Waterbury Filing Nos. 1 and 2
 Traffic Impact Analysis
 PUDSP215 SF237 2
 (LSC #204220)
 July 20, 2022

LSC Responses to TIS Redline Comments (on the PUD Study)

RE: Waterbury Filing Nos. 1 and 2
El Paso County, Colorado
Traffic Impact Analysis
PUDSP215 SF237
LSC #204220

Figure 4  
**School Pedestrian Routes**

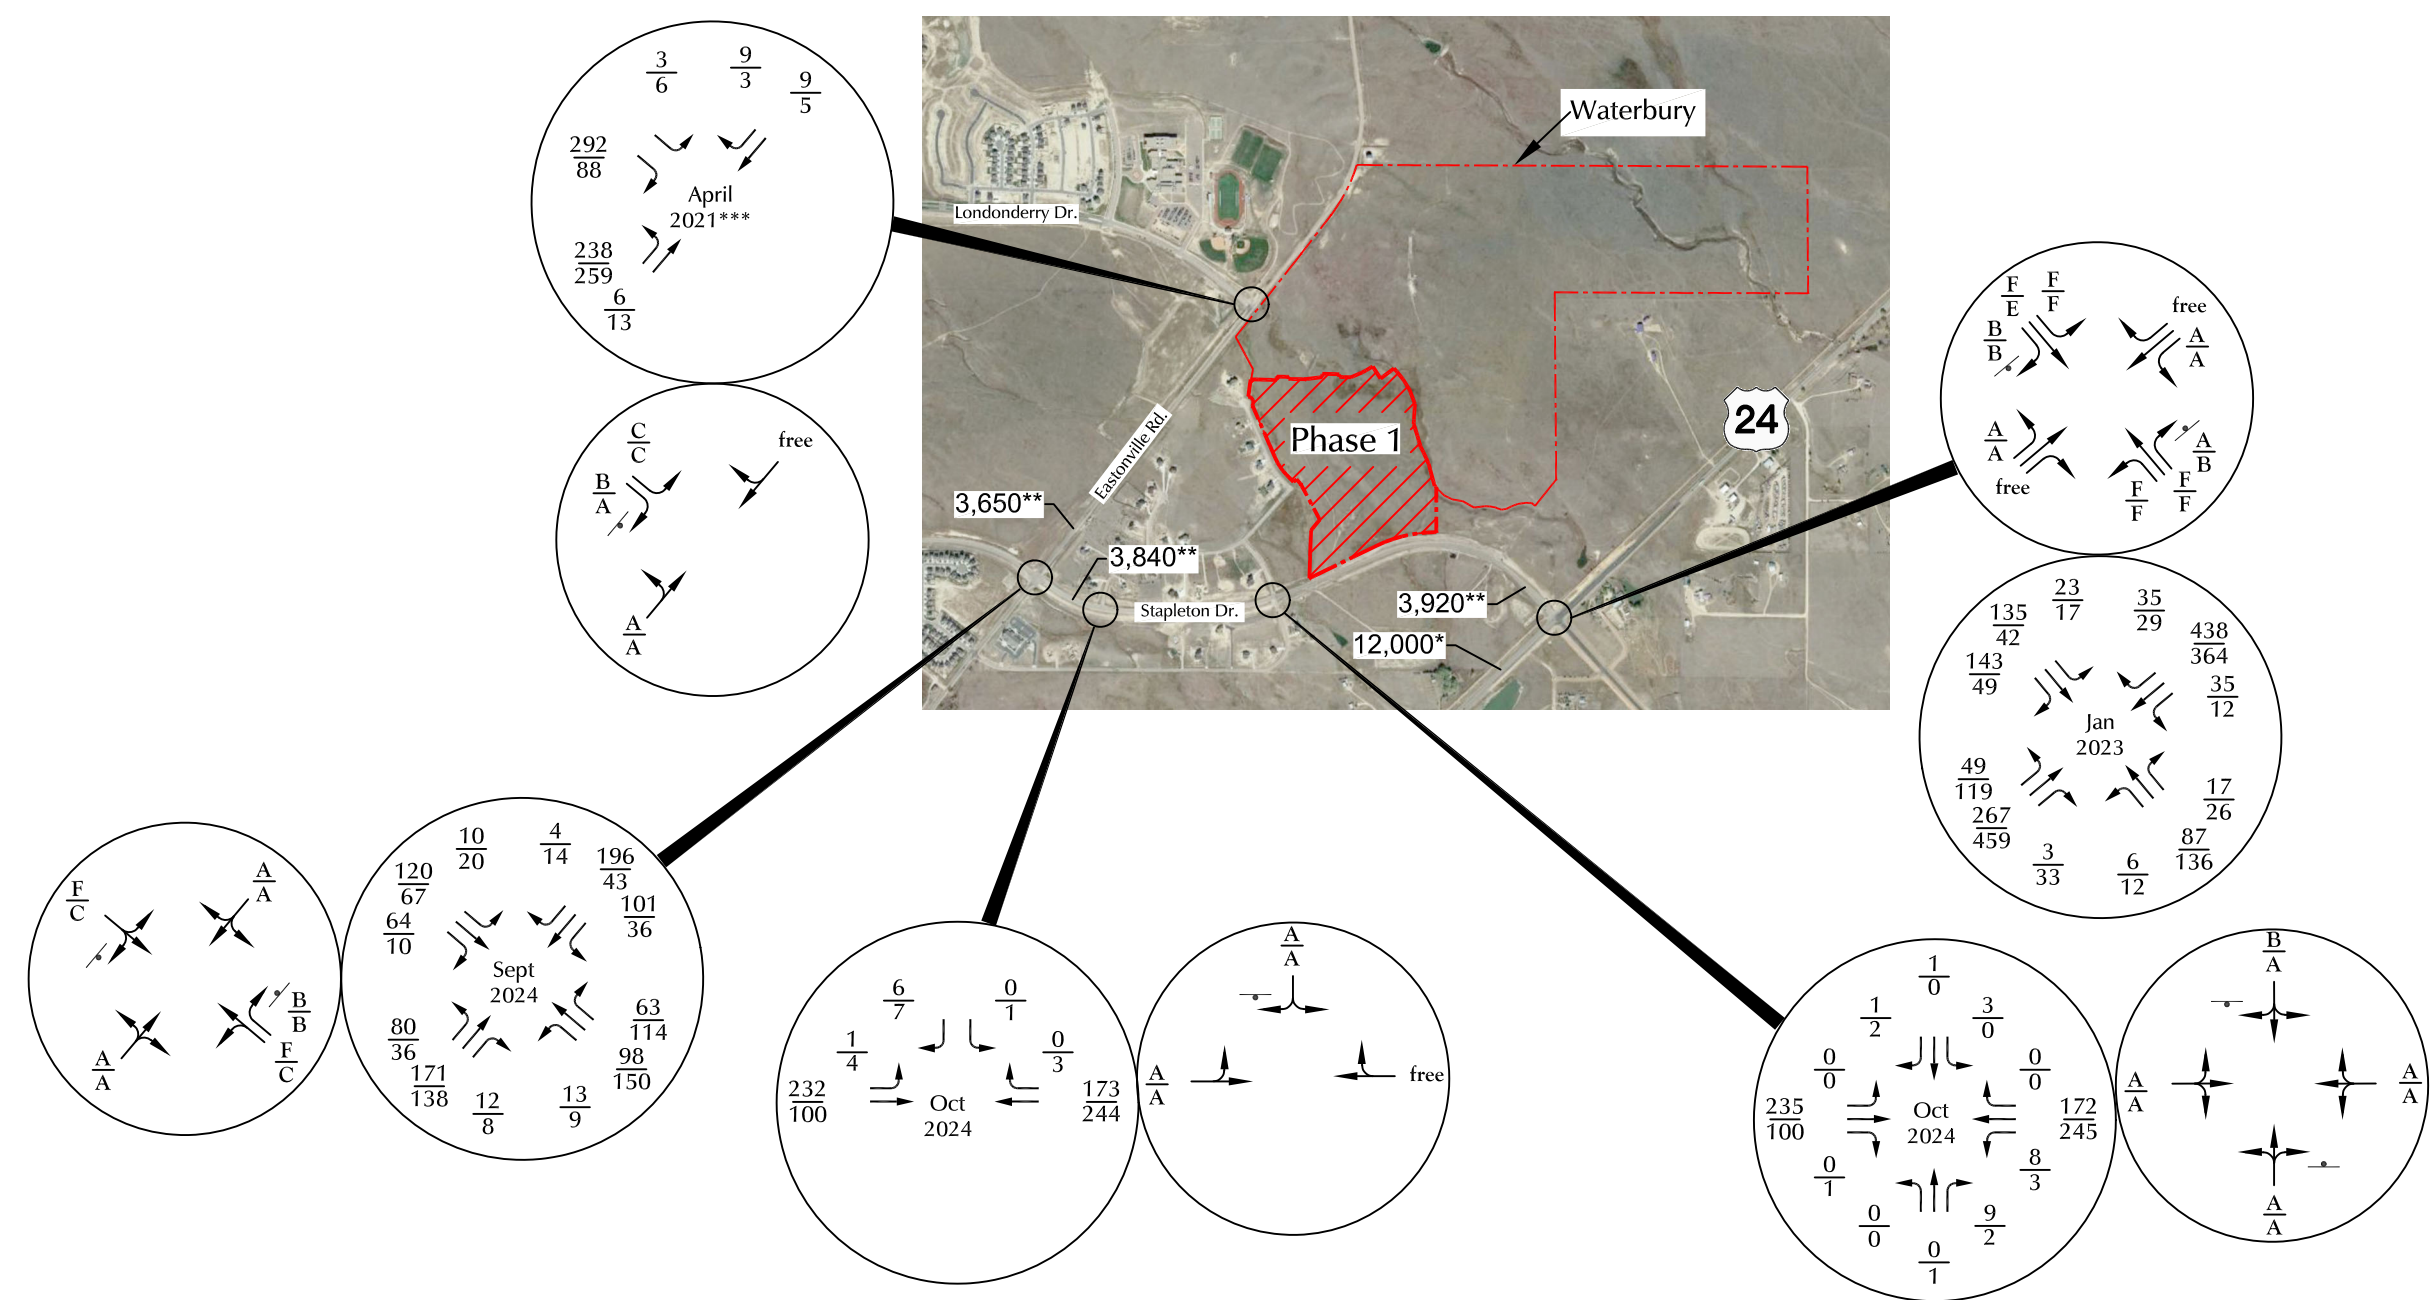
Figure 4 shows the school pedestrian routes. There are currently no sidewalks on Stapleton Drive and on Eastonville Road. [Indicate if there are plans for sidewalk to be installed in the future.](#) ¹

Number: 1 Author: kdfer Subject: Text Box Date: 10/4/2024 11:13:27
[Indicate if there are plans for sidewalk to be installed in the future.](#)

LSC Response: Revised as requested

Figure 5  
**Existing Traffic,  
 Lane Geometry and Traffic Control**

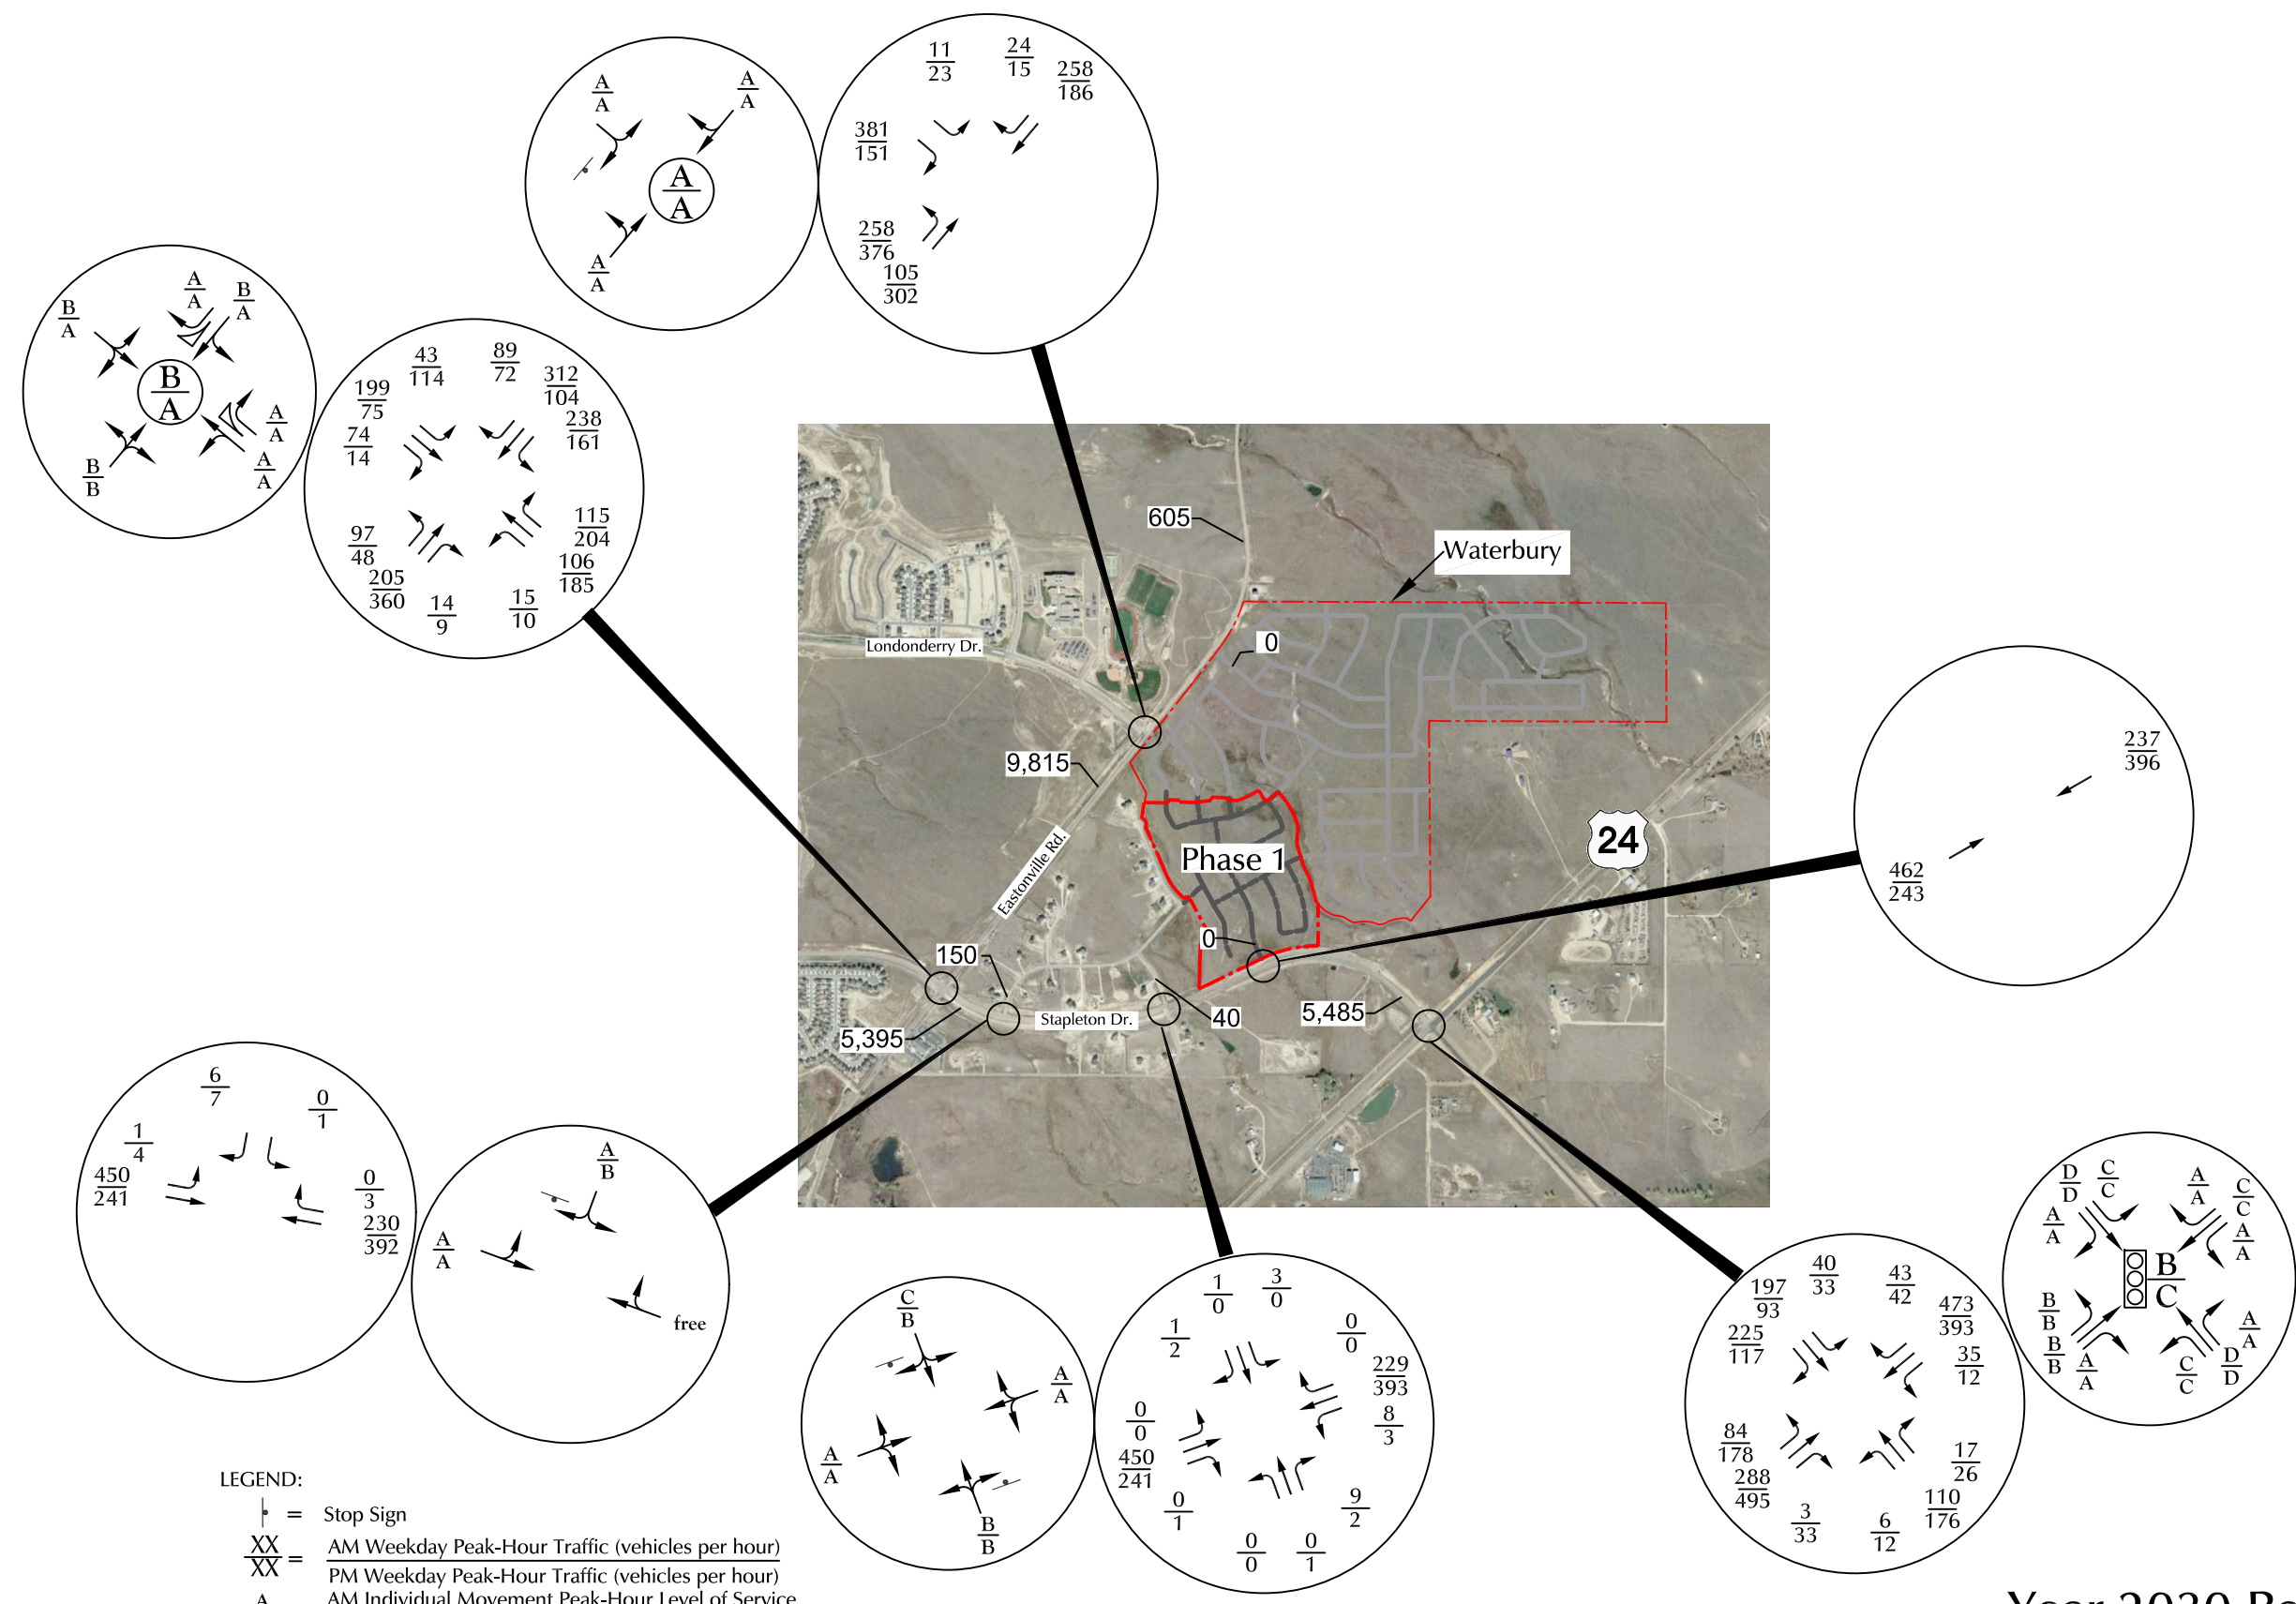
CDOT has newer information from 2021. ¹

[CDOT has newer information from 2021.](#)

LSC Response: Updated data has been provided as requested

Figure 6  
 Year 2030 Background Traffic,  
 Lane Geometry and Traffic Control

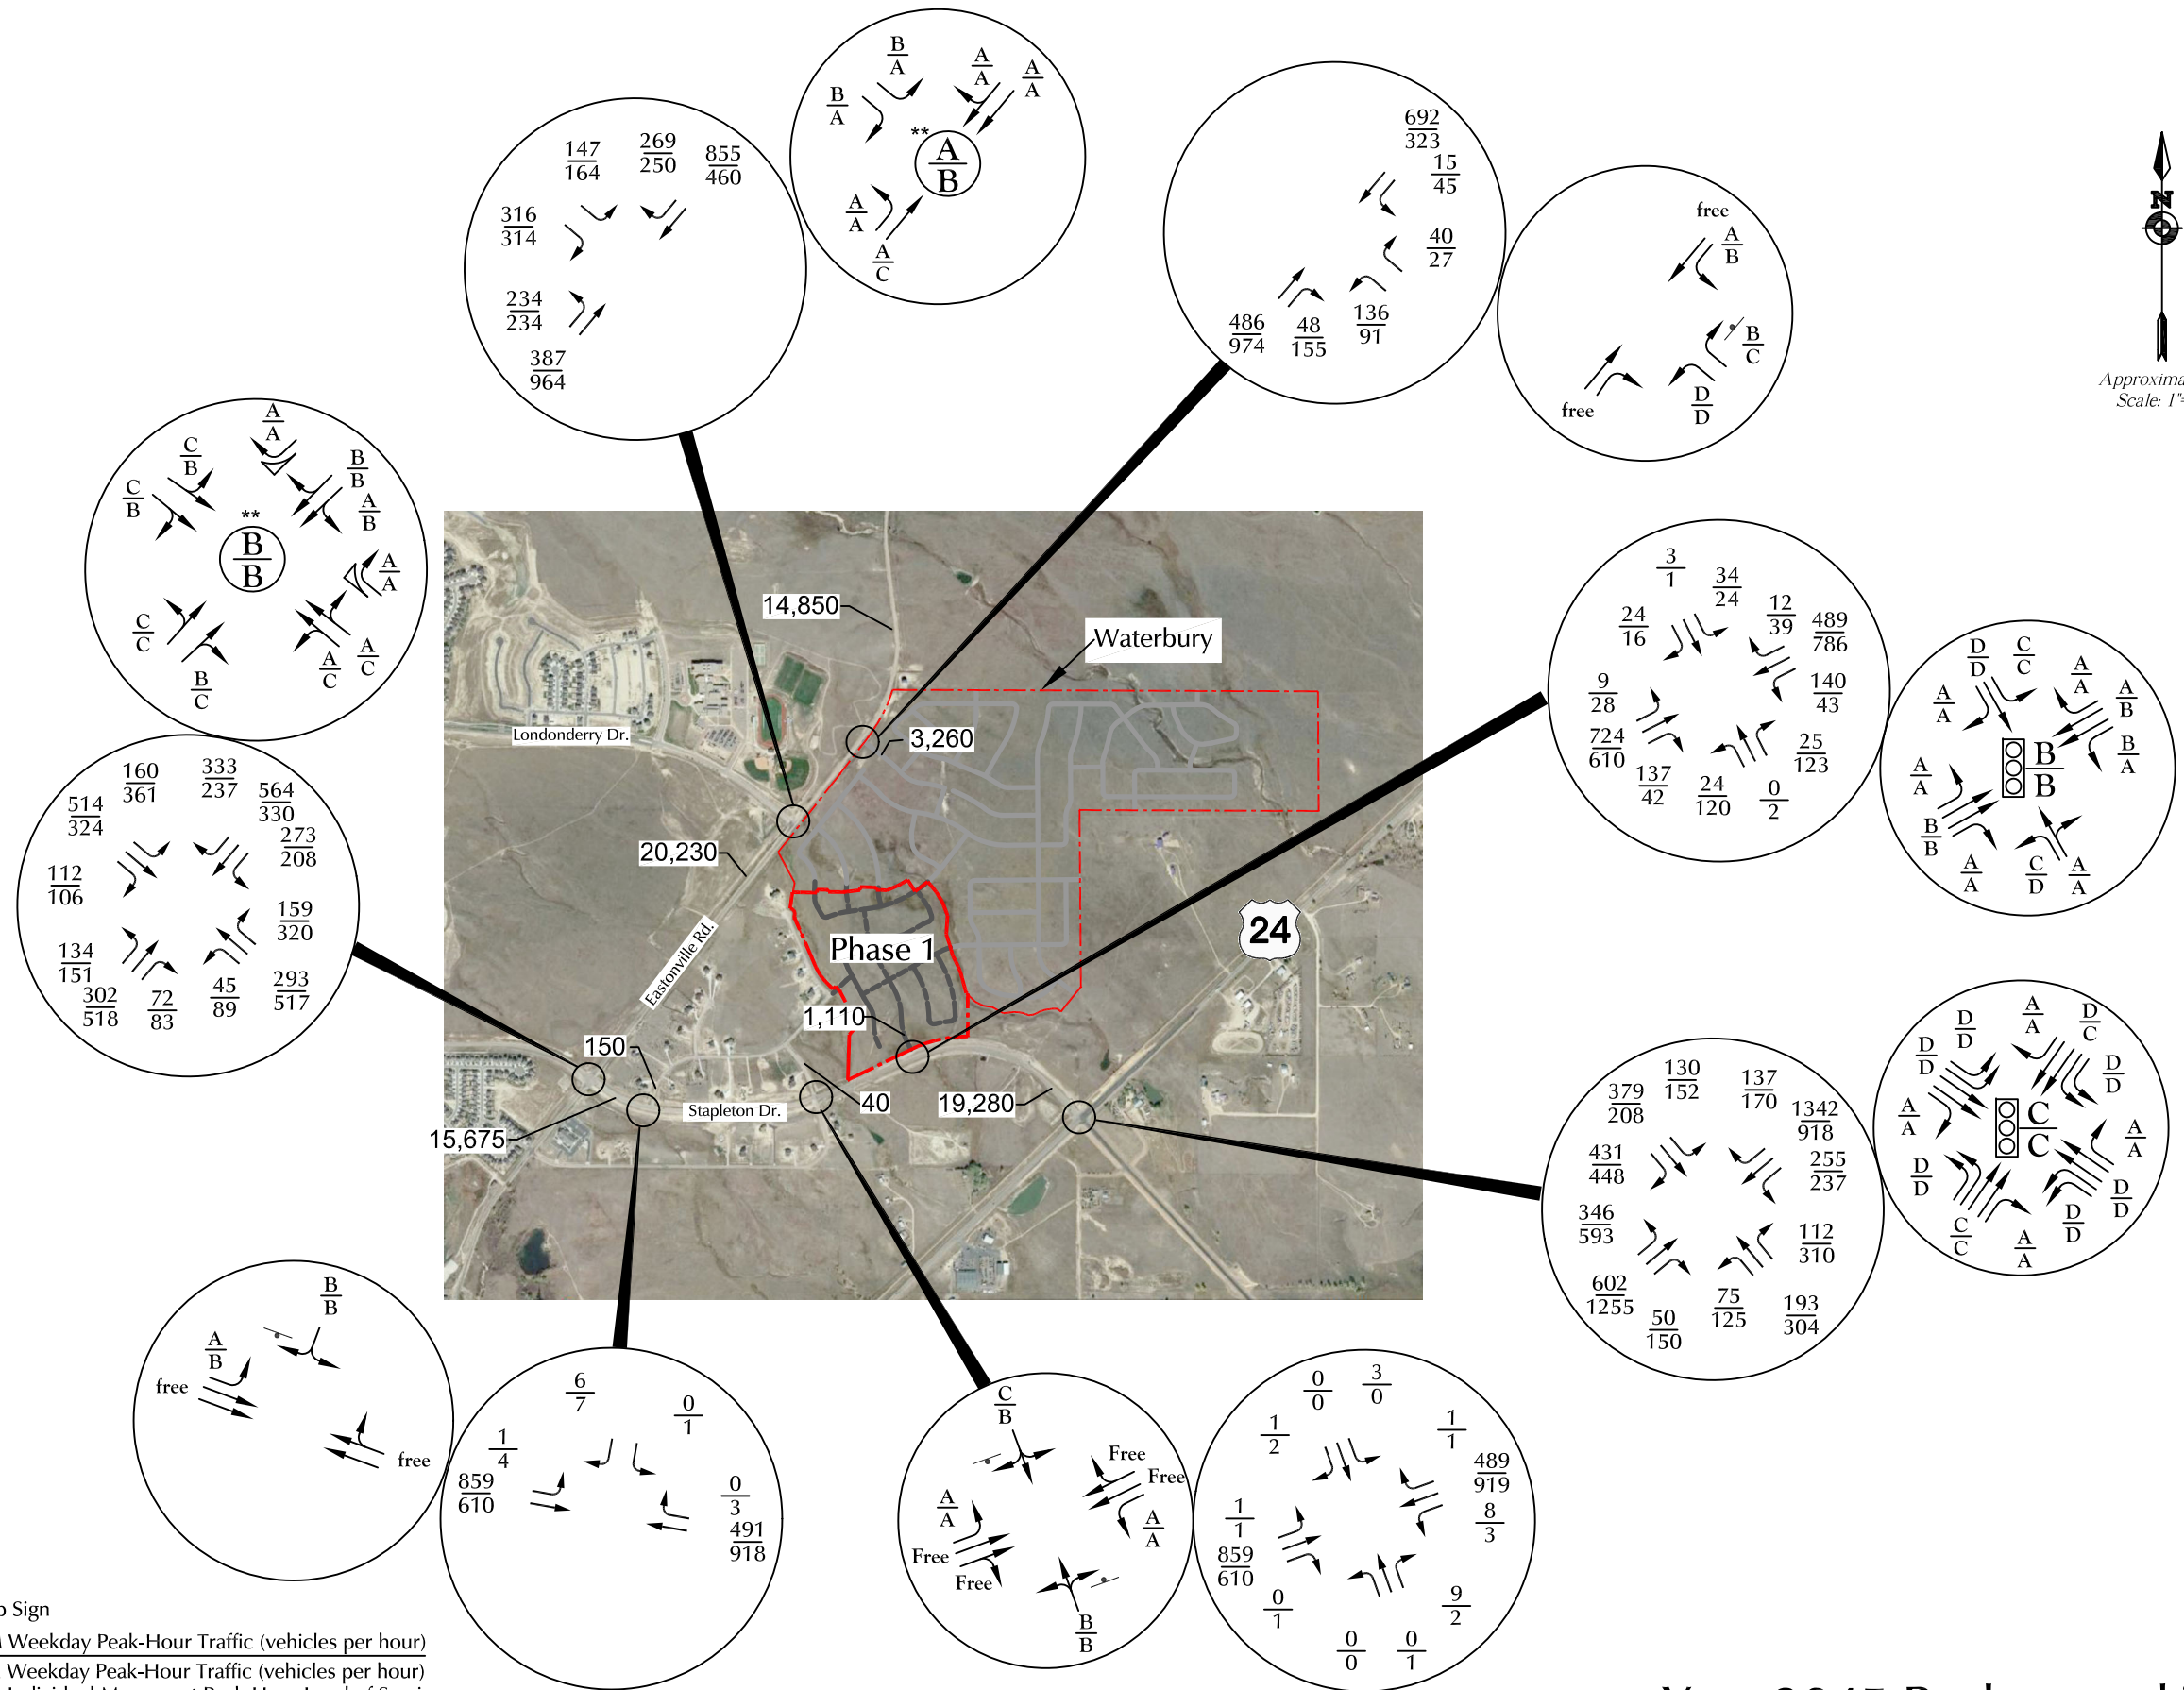
[2028? One year after full buildout per Appendix B.2.2](#)

LSC Response: The short-term year has been updated to 2030
